From: Murphy, Alexander N [<mailto:alexander.murphy@mottmac.com>]
Sent: 15 November 2018 22:12
To: A303 Sparkford to Ilchester
Cc: Hayes, Elliot; Sanderson, Hannah; Paula McGeady; A303 Sparkford to Ilchester Dualling (A303SparkfordtoIlchesterDualling@highwaysengland.co.uk)
Subject: A303 Sparkford to Ilchester - S51 revised documents to PINS.

Please find below a response to the S51 advice together with an FTP site hosting the required files.

Drawing Title: FIGURE 2.3 GENERAL ARRANGEMENT PLANS SHEET 5 OF 7

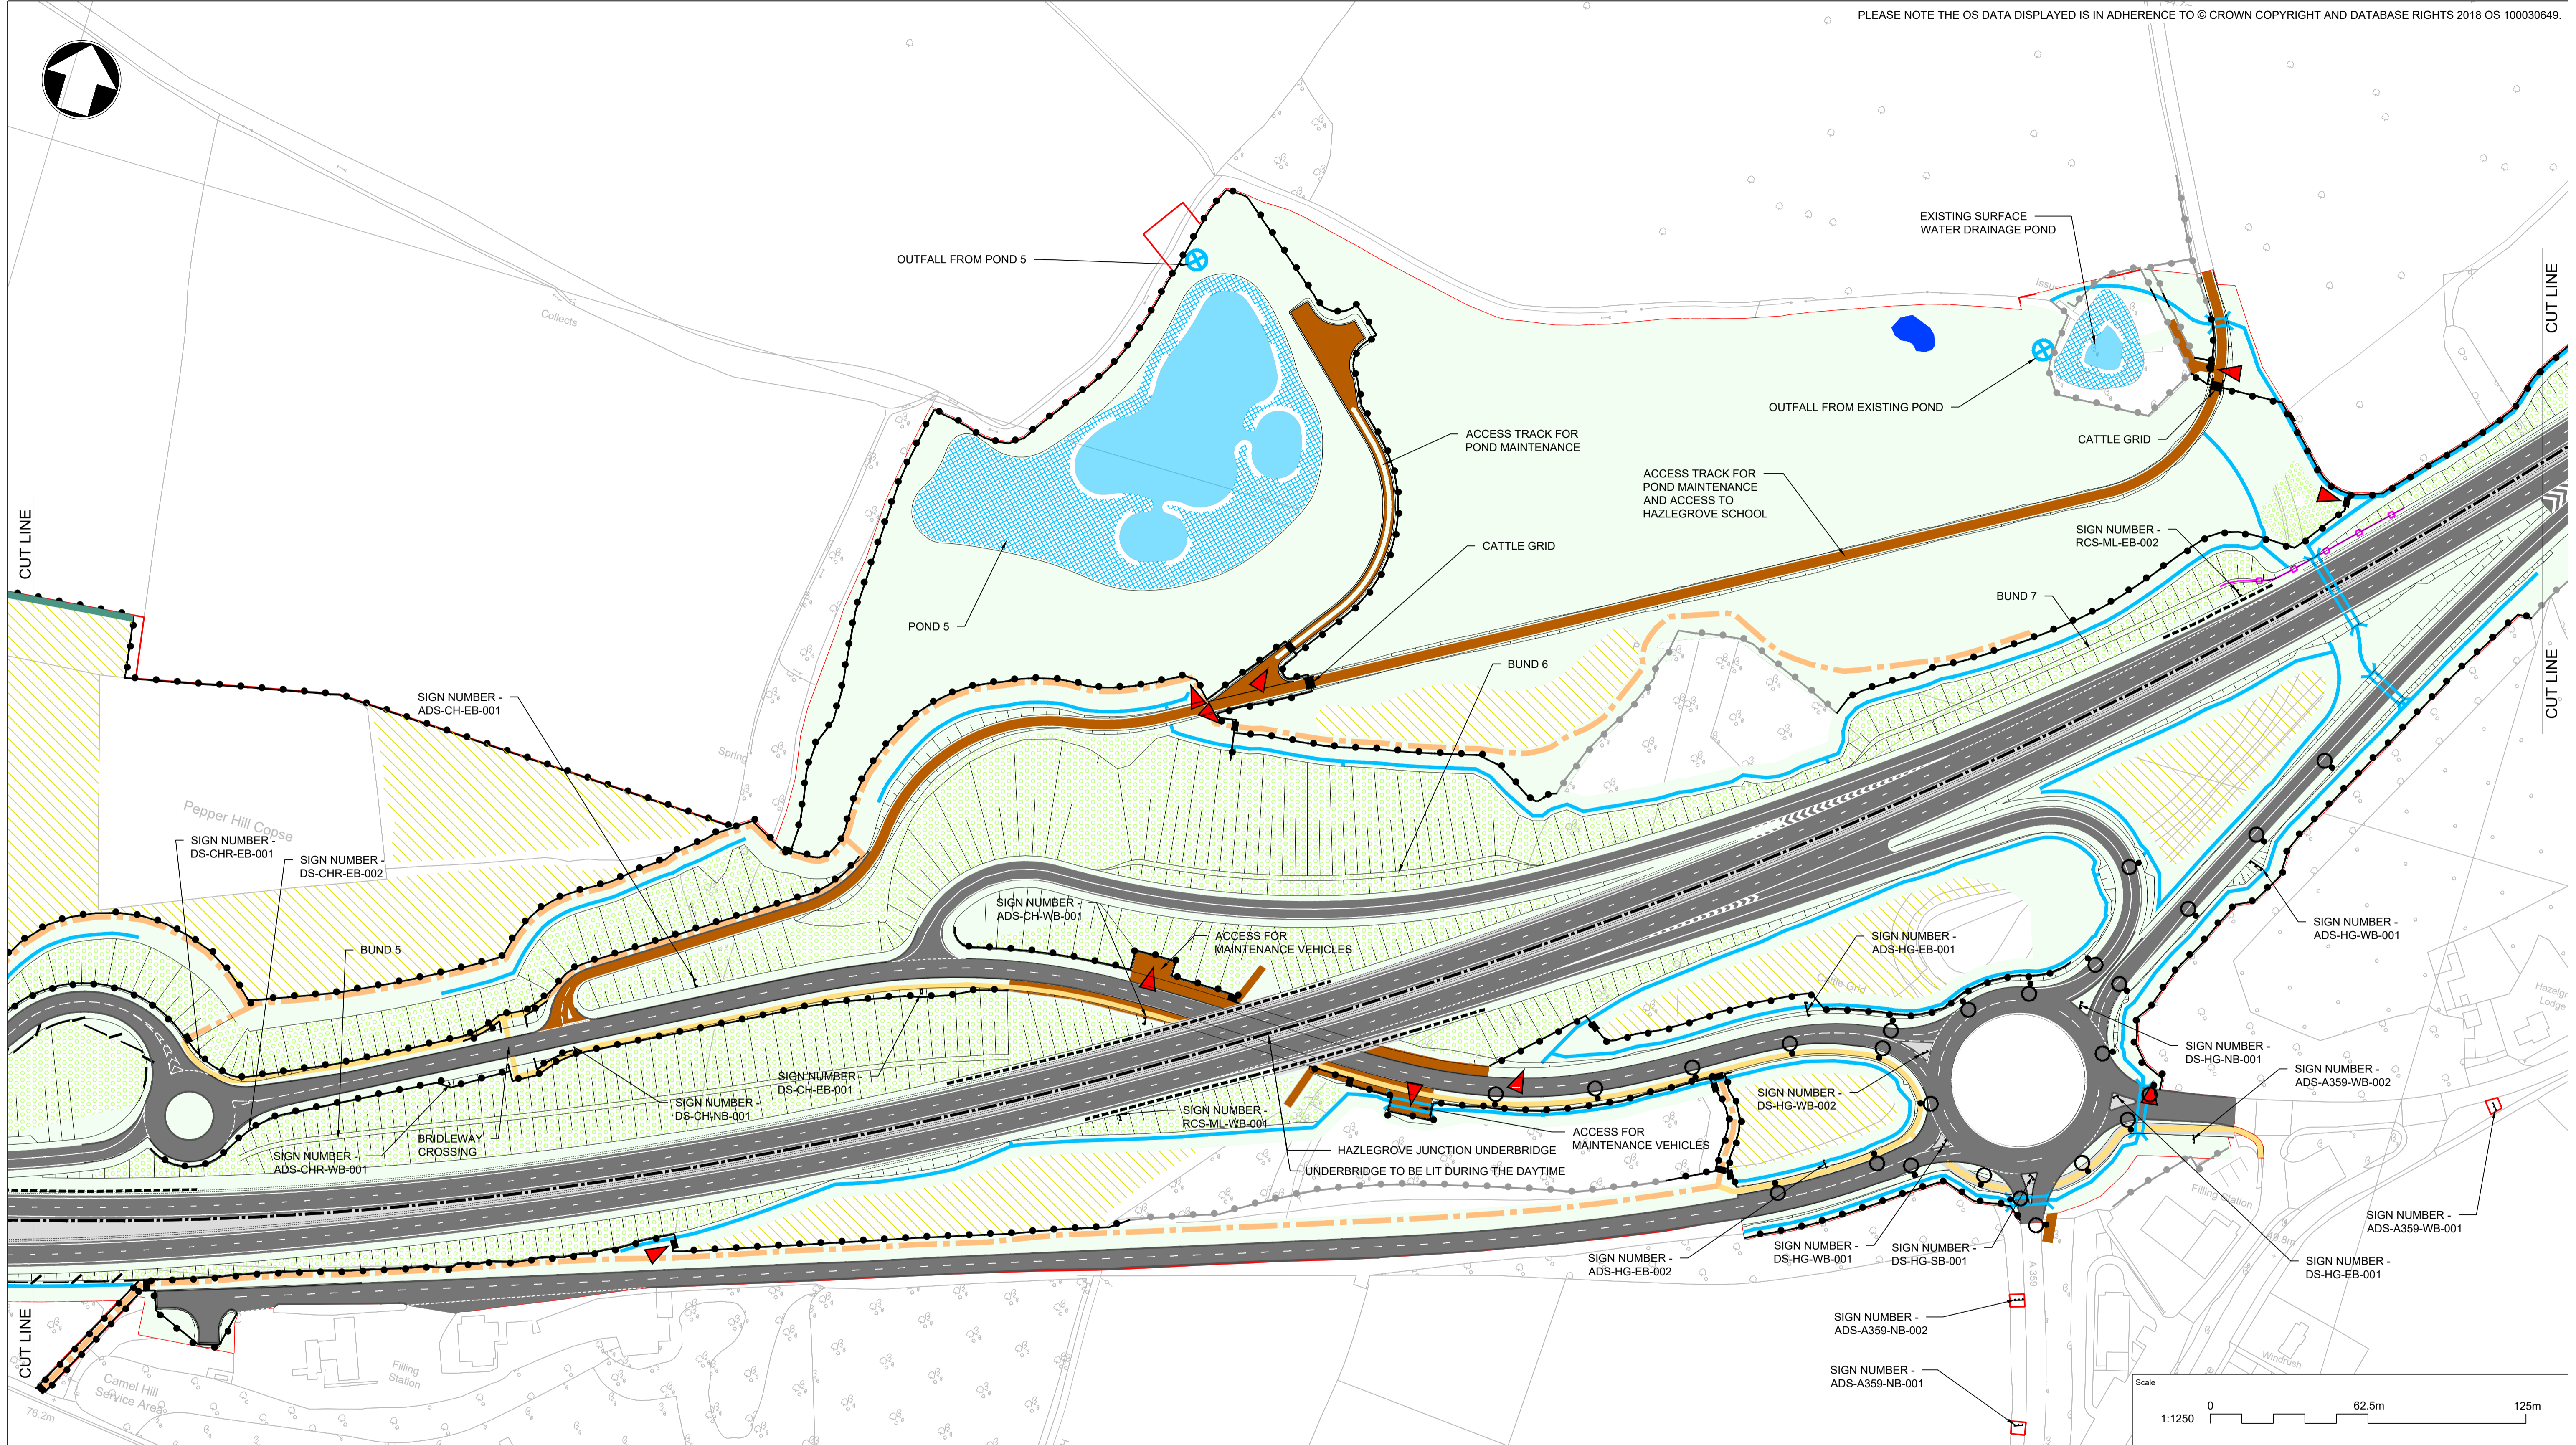
Traits Lane turning head on the original version of Sheet 5 of the General Arrangement Plans. This was a drafting error. Sheet 5 has been corrected.	
--	--	--

| Drawing Title FIGURE 2.4 RIGHTS OF WAY AND ACCESS PLANS - SHEET 3 OF 4 REGULATION 5(2)(k) and 5(2)(o) | | | | | |

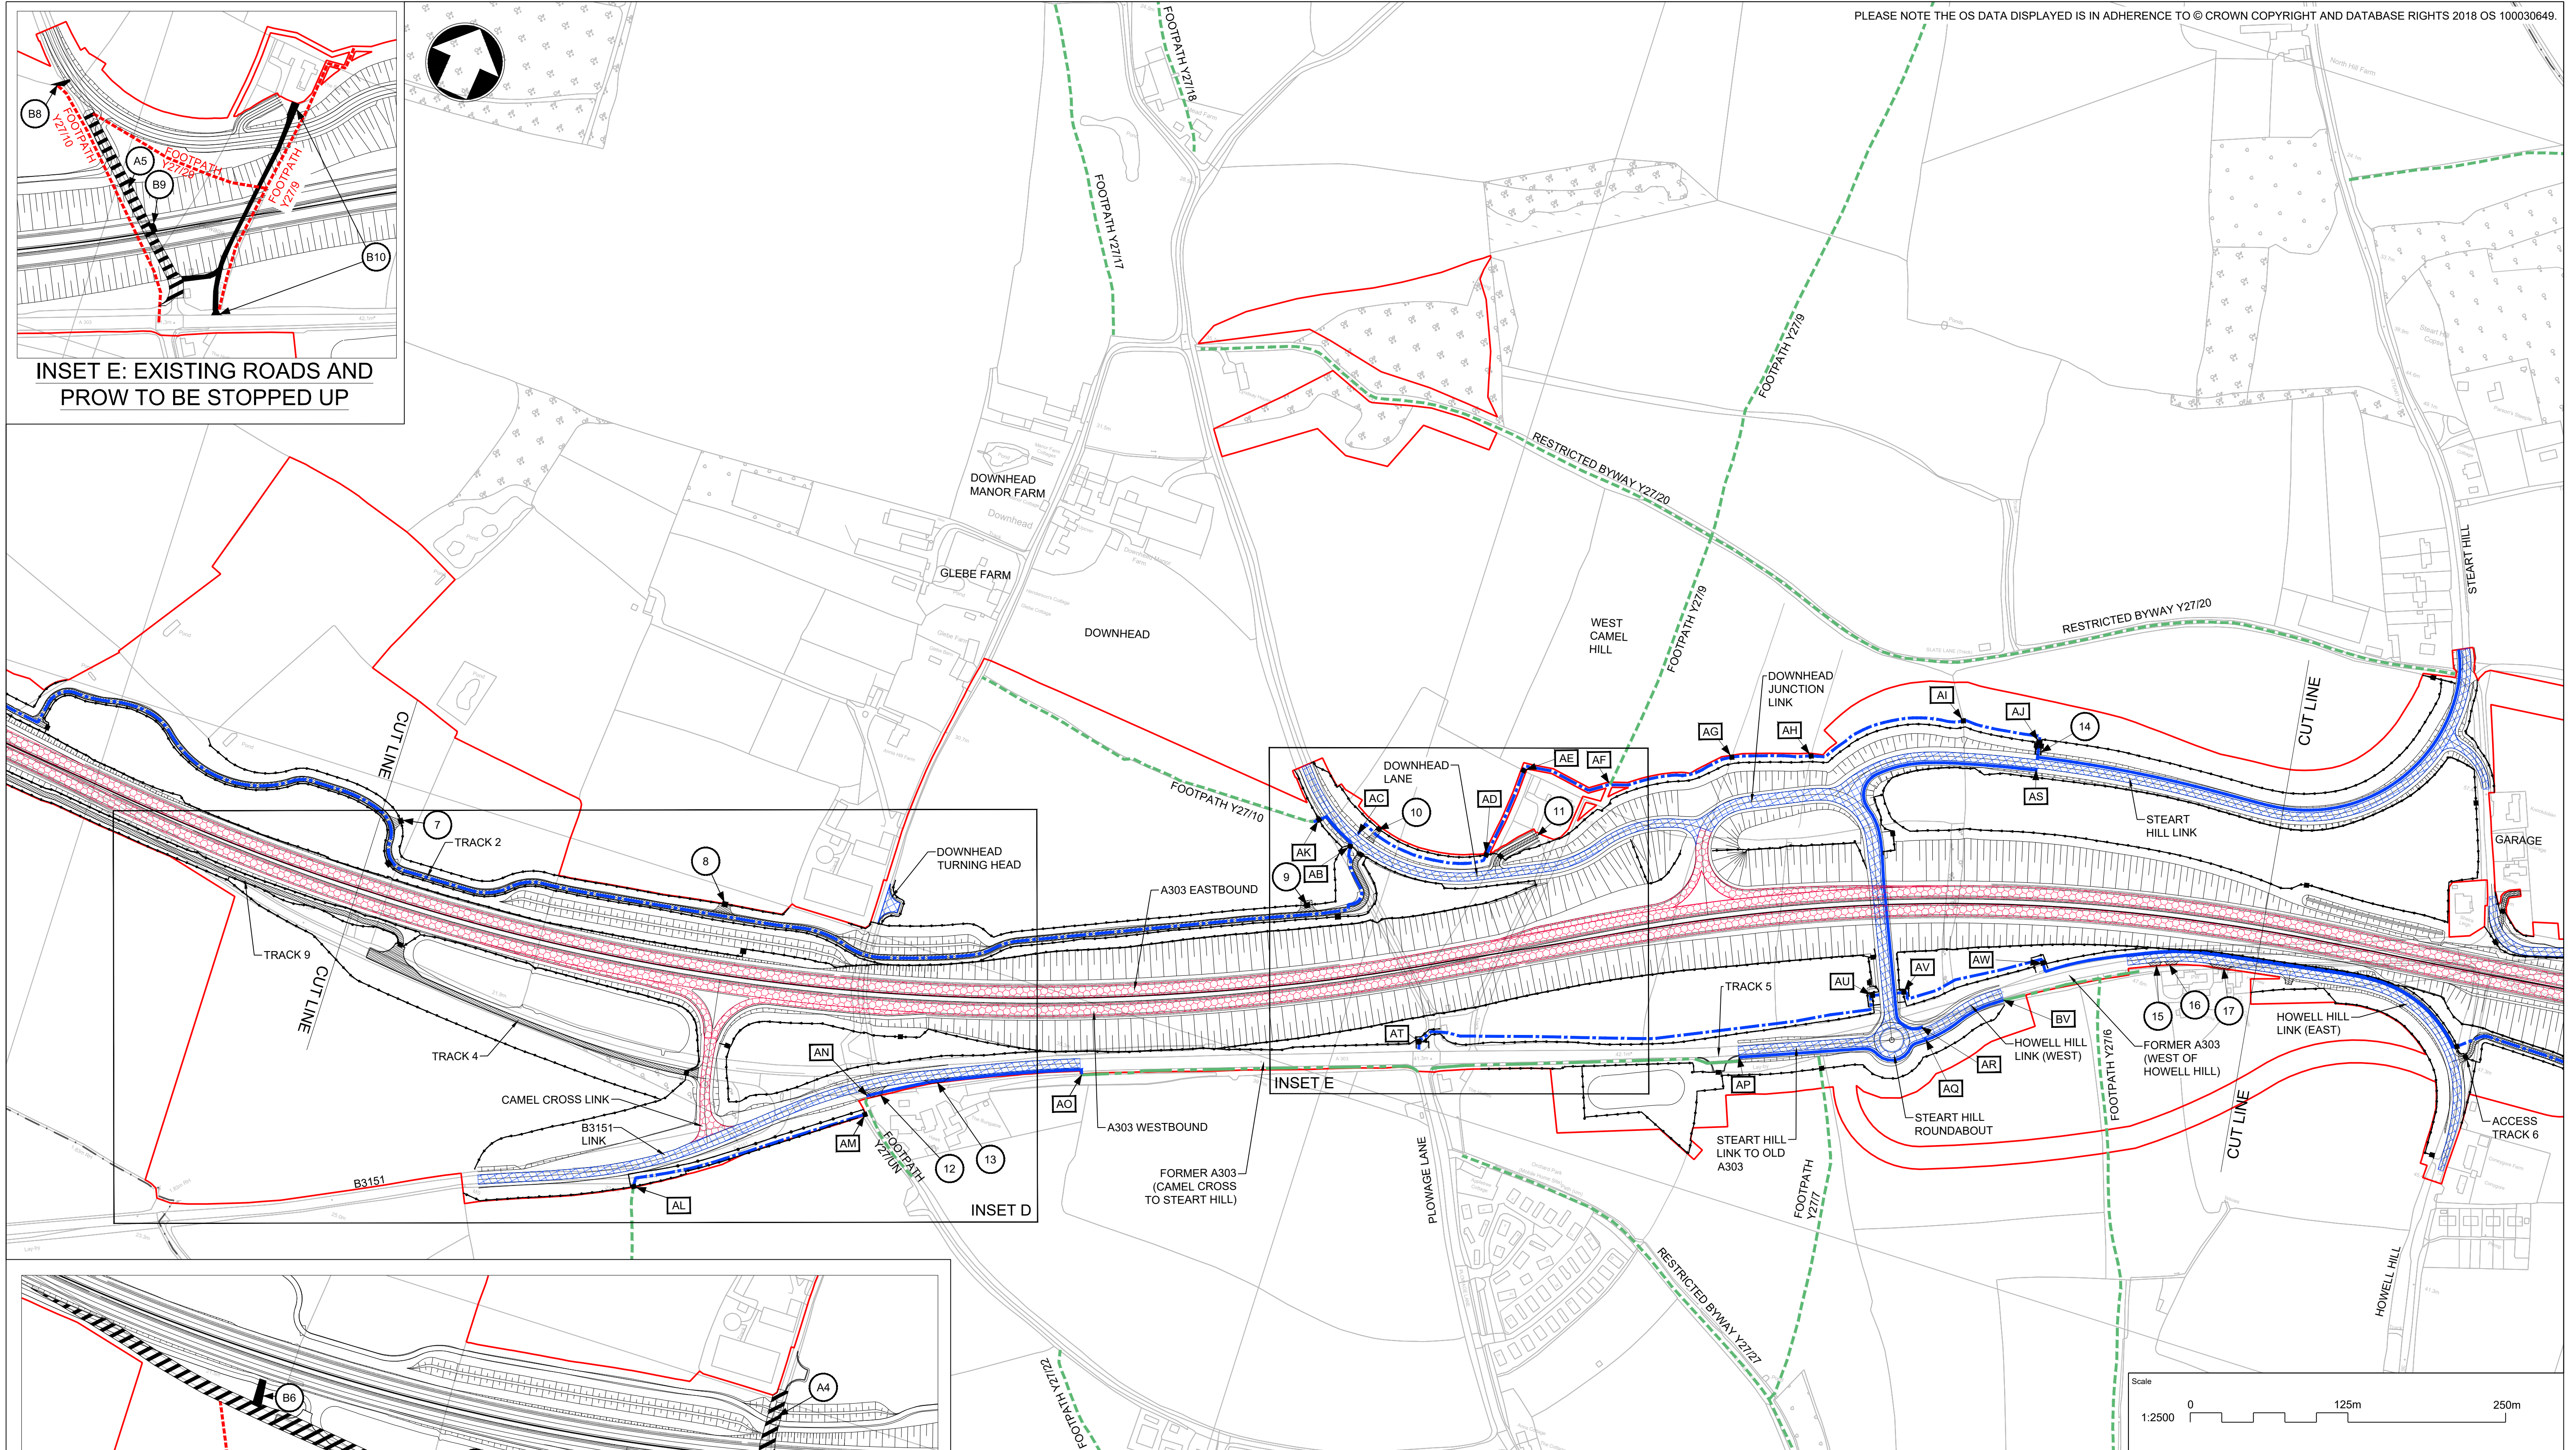
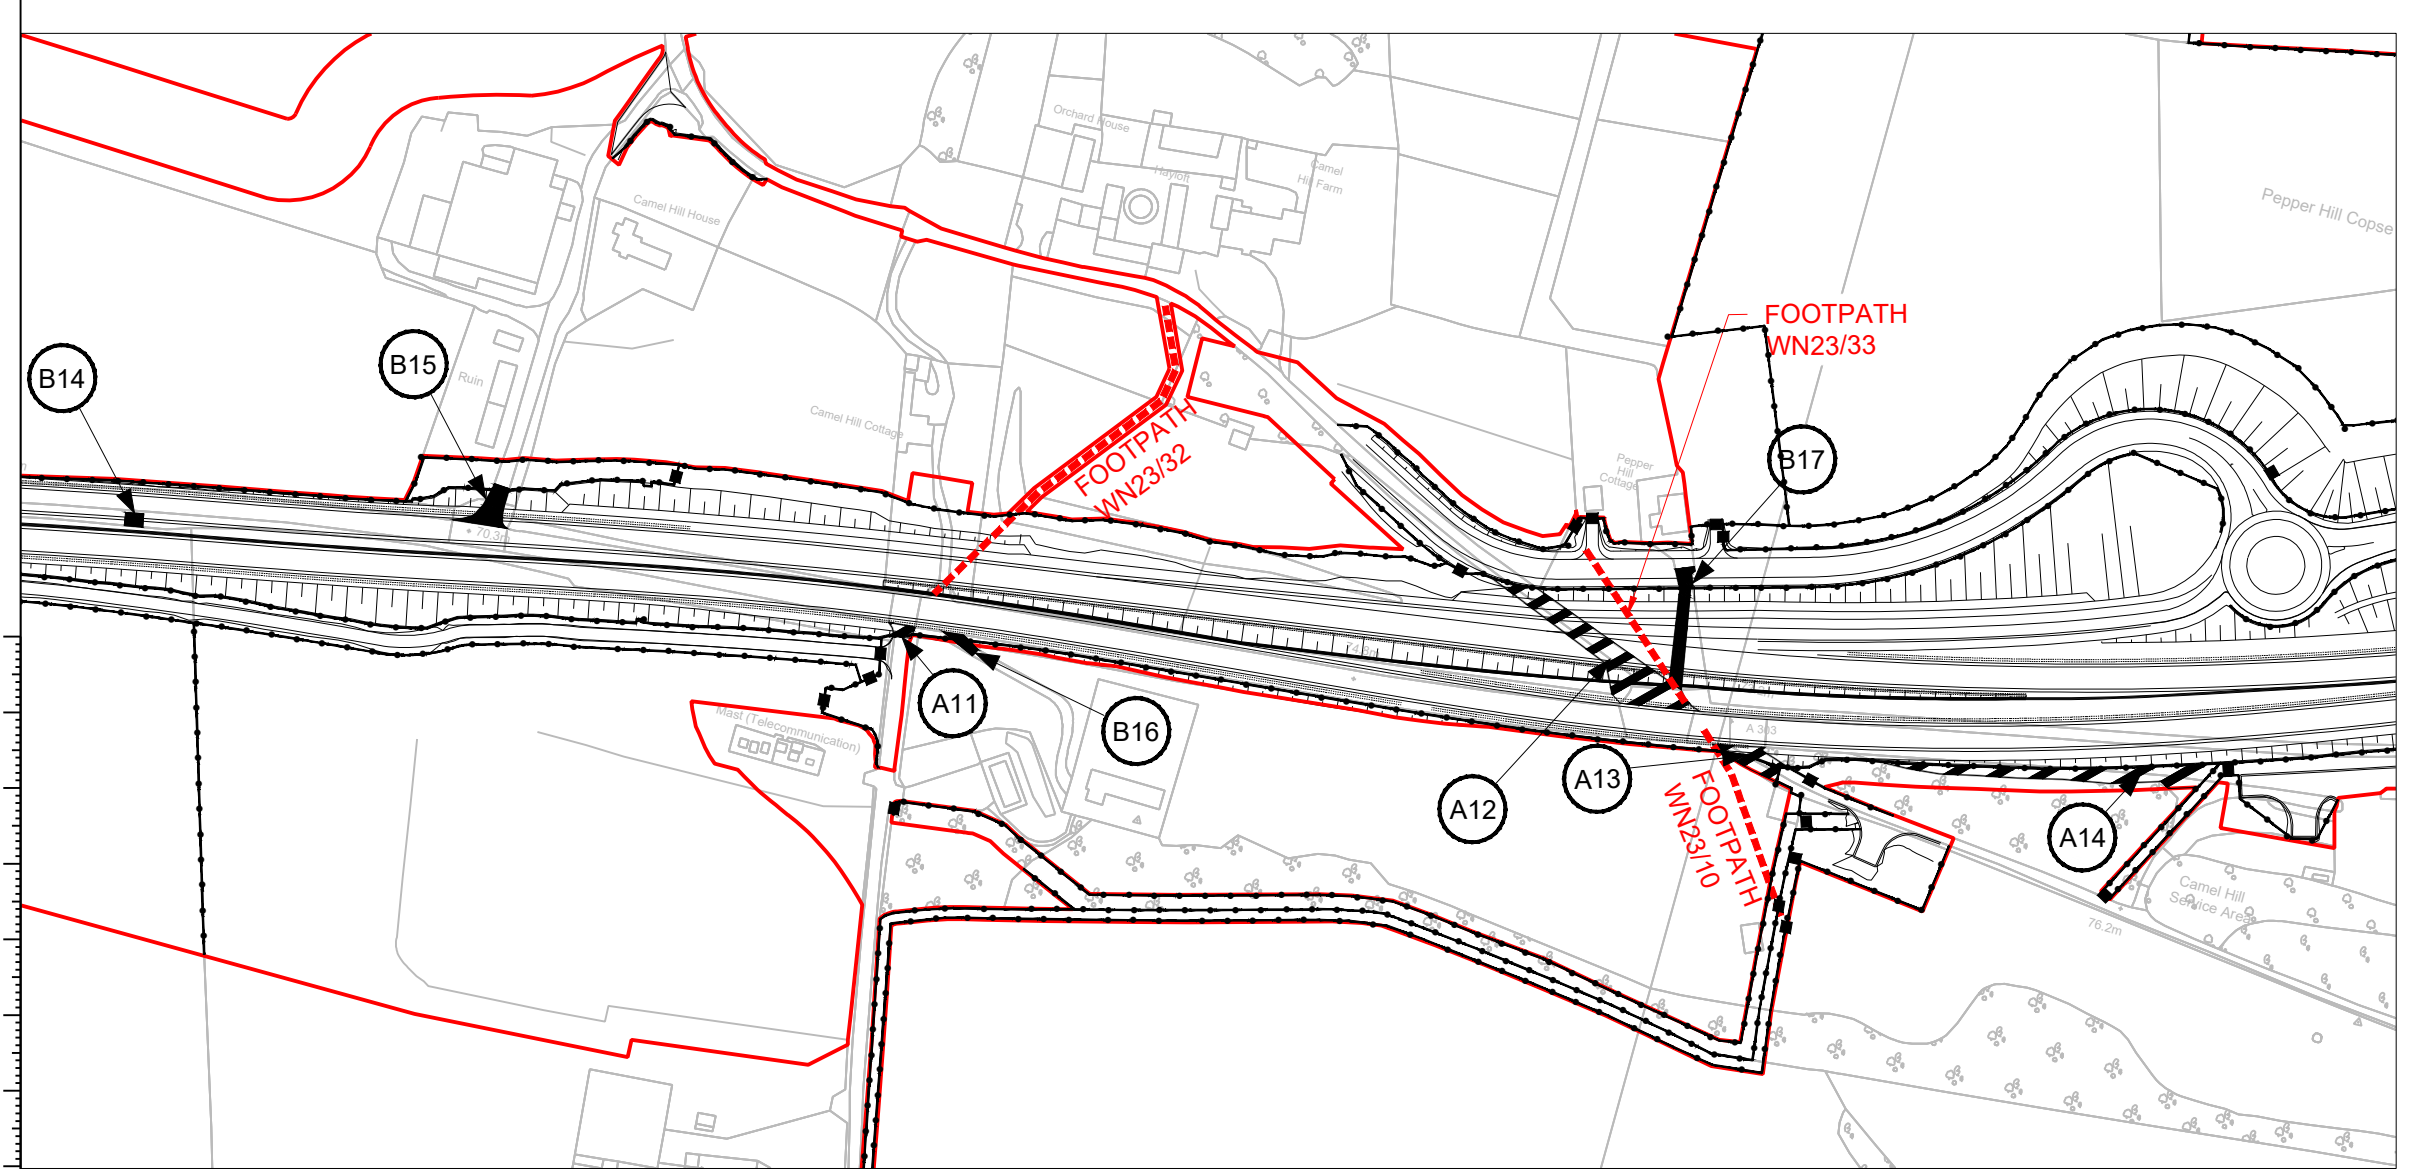
<p>-</p>	<p>Inset F of Sheet 3 of the Rights of Way and Access Plans (Document 2.4) was blank in the original version of the drawing. This was a drafting error. Sheet 3 has been corrected.</p>	<p>HE551507-MMSJV-LSI-000-DR-UU-2044 Rev C02</p>
<p>-</p>	<p>Surfacing and proposed hedgerows were not correctly shown at</p>	<p>HE551507-MMSJV-LSI-000-DR-UU-2066 Rev C02</p>
